Located At 1854 FOREST AVE

Job ID: 2011-11-2770-ALTCOMM

has permission to Amend Permit # 2011-06-1396, add a plumbing chase, shower, future shower plumbing & exterior stairs provided that the person or persons, firm or corporation accepting this permit shall comply with all of the provisions of the Statutes of Maine and of the Ordinances of the City of Portland regulating the construction, maintenance and use of the buildings and structures, and of the application on file in the department.

PROJECT NAME: 1854 Forest Ave (Dojo)

3 NEW EXTERIOR STAIR PROFILE
 A3 SCALE: 1/2" = 1'-0"

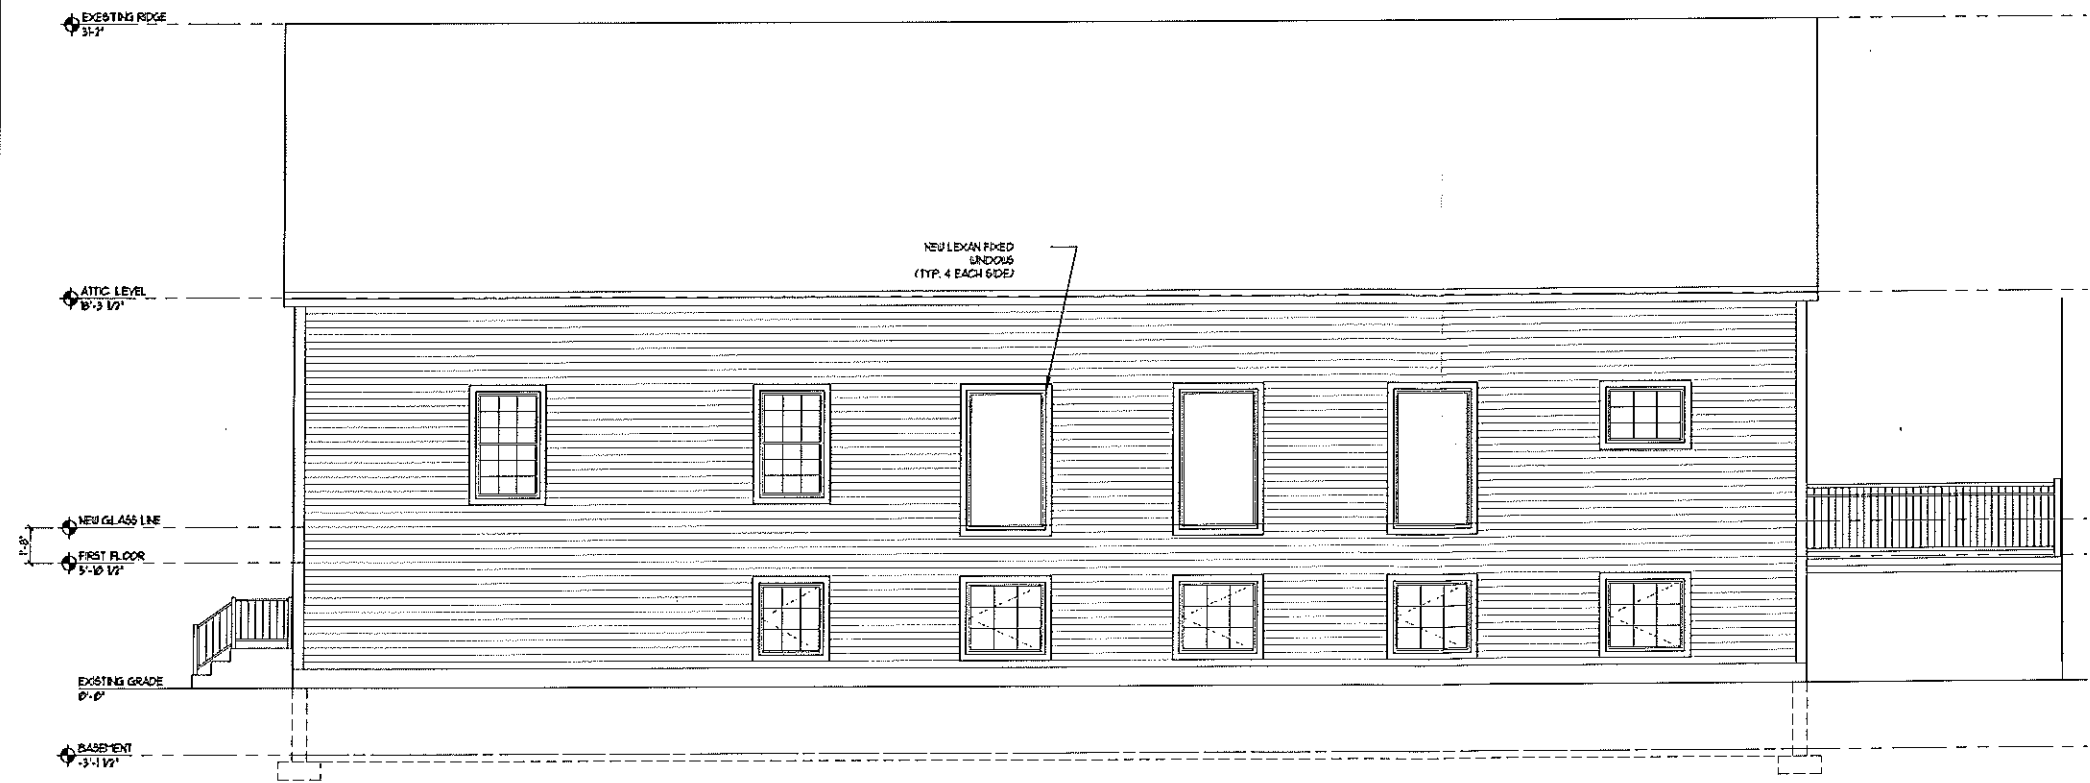
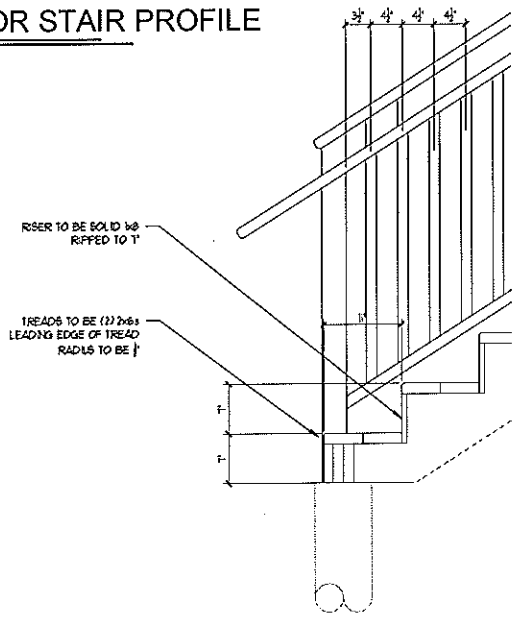
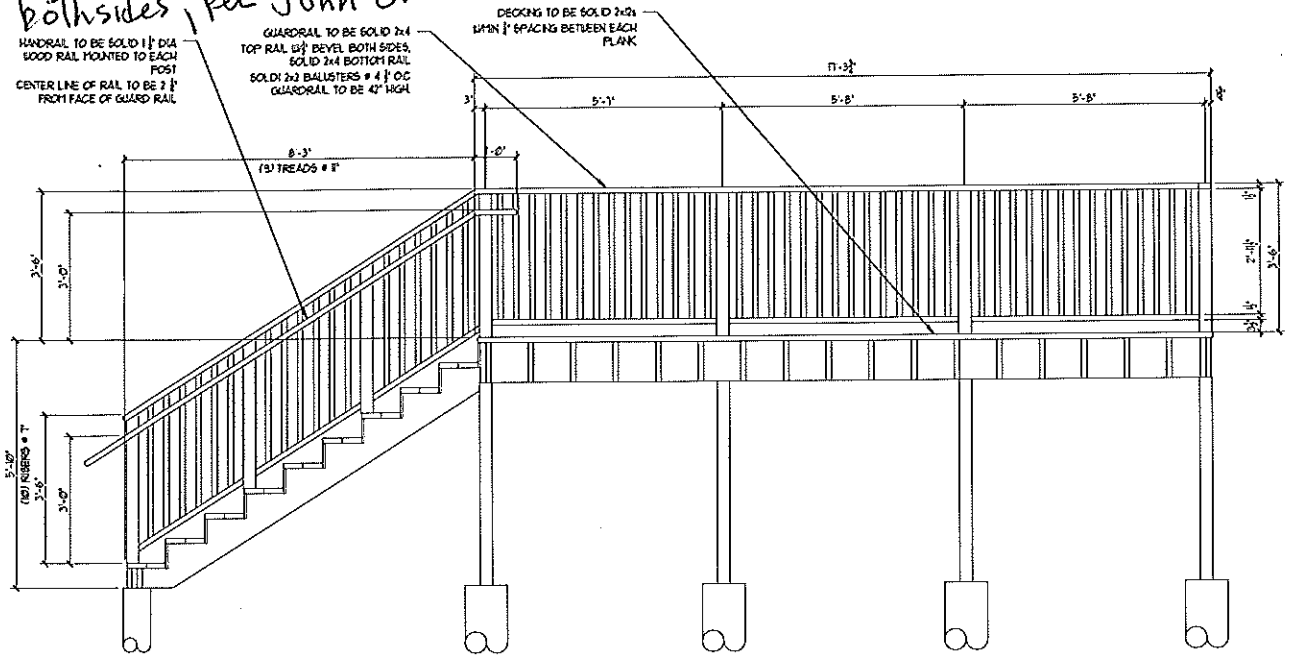
Thanks John,
 Just note that the handrail is required on both sides of the stair, I can make a note on the plan or you can revise.
 Let me know.
 Jeanie

1. While the IBC Sec. 1009.4.5 Stair Profile is not as specific about nosing projections on vertical risers, the NFPA Sec. 7.2.2.3.3.2 is, therefore the 3/4" nosing as design will not be accepted.
2. Please see IBC Sec. 1012 Handrails and 1013 Guards for a complete description of the required specs at commercial properties. Note: 1013.1 Guards, Where required, **stairs**.
